Our Ref: FG/82/22/NMA

Non material amendment following FG/178/21/HH to increase the height of the dormer on the existing roof and the dormer that is being built over the two storey side extension.

12 Colindale Road North Ferring BN12 5LB

NEW PROPOSED ELEVATION TO BE APPROVED

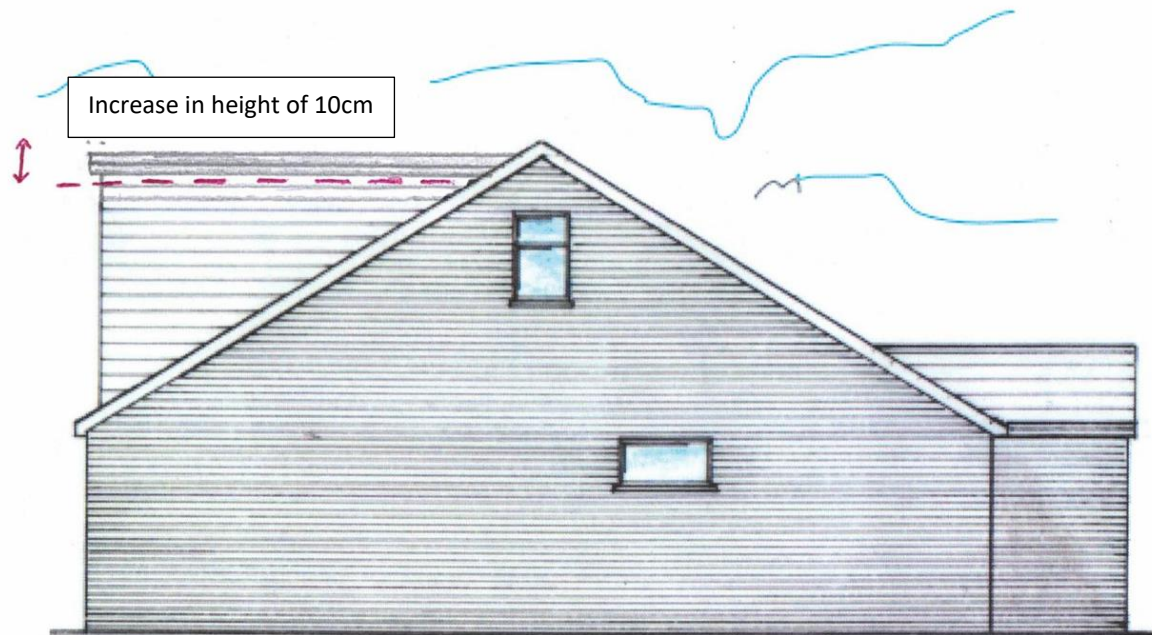
The difference in height of the dormer of 10cm is within the above stated tolerances. This change will not materially alter the appearance of the development approved by the planning permission, does not conflict with any conditions of the permission, does not breach any planning policy and does not warrant re-consultation. The changes can be considered as an NMA under section 96A of the Town and Country Planning Act 1990.

The revised side and rear elevation drawings, received on 13-06-2022 which are not scaled, but do identify the dimension differences between the approved plans and the alterations proposed, are acceptable and therefore replace the equivalent drawings approved by FG/178/21/HH.
